ATTENTION: DIRECTOR – KEY SITE ASSESSMENTS

State Significant Development Application Number SSD-10300.
Coffs Harbour Cultural and Civic Space.

GORDON ST ELEVATION

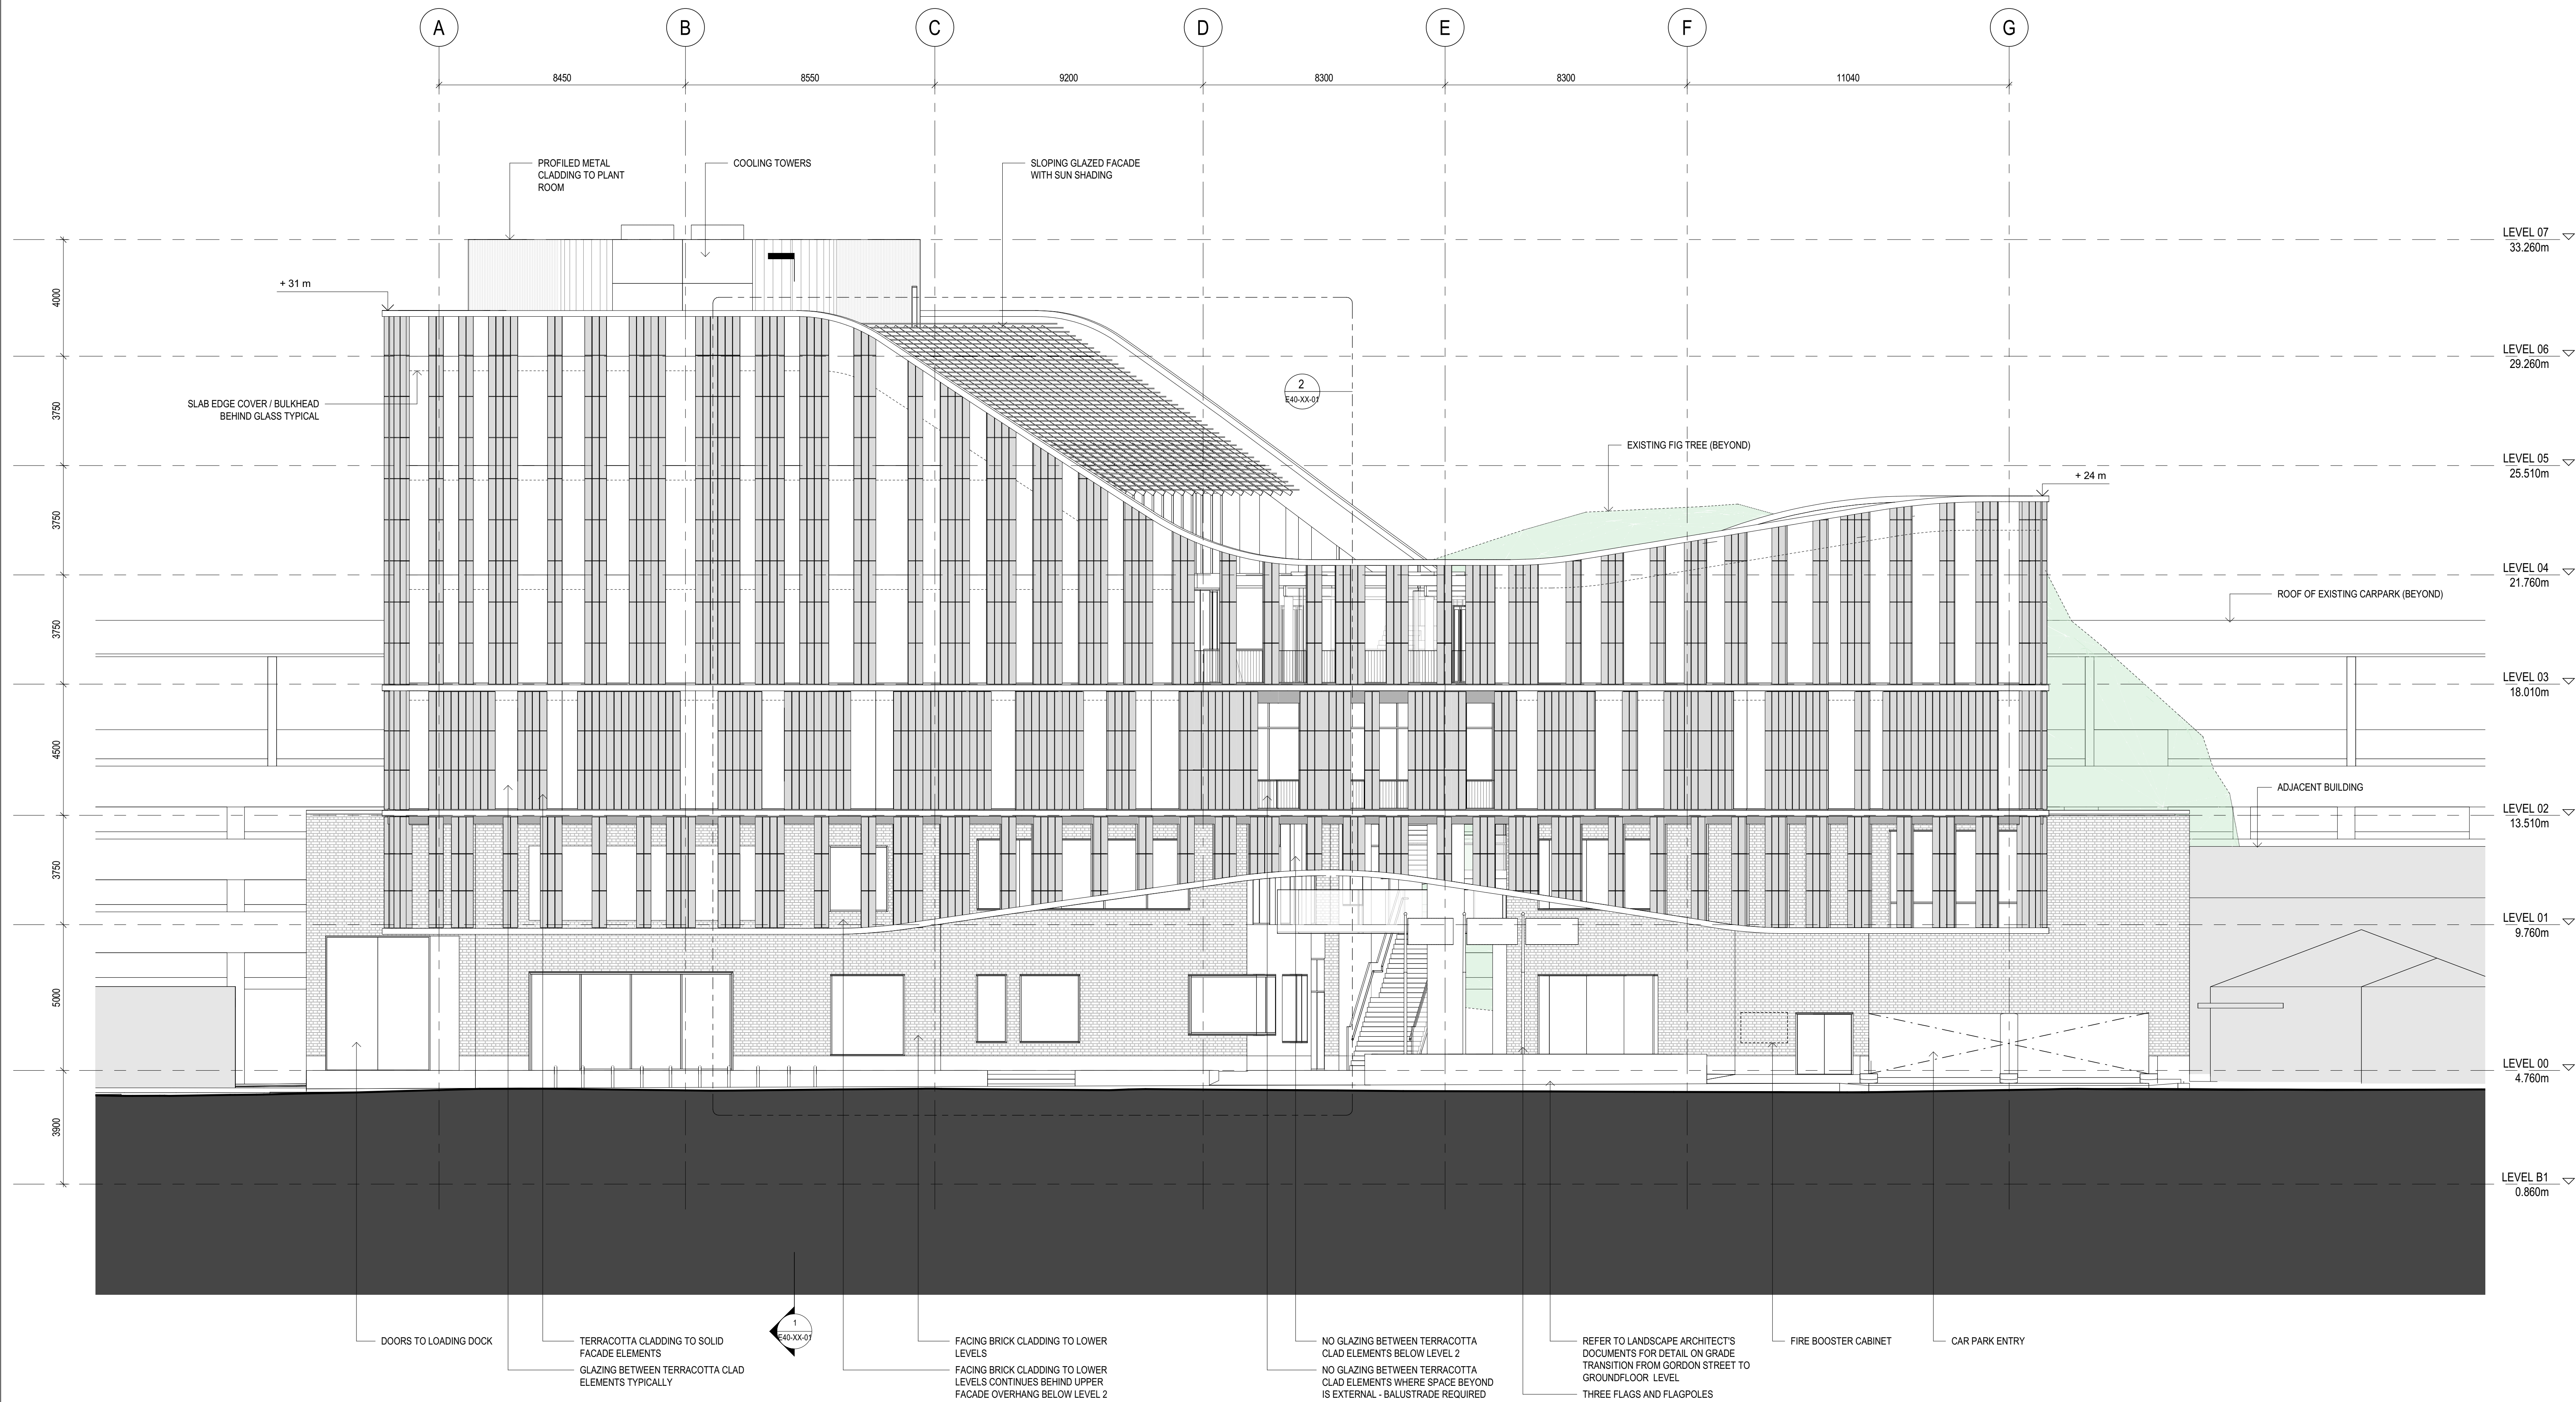
3. It conflicts with the streetscape in Gordon Street in that the proposed building is outside the context of this street having regard to the scale, existing street setbacks, design and general form of the adjoining buildings.
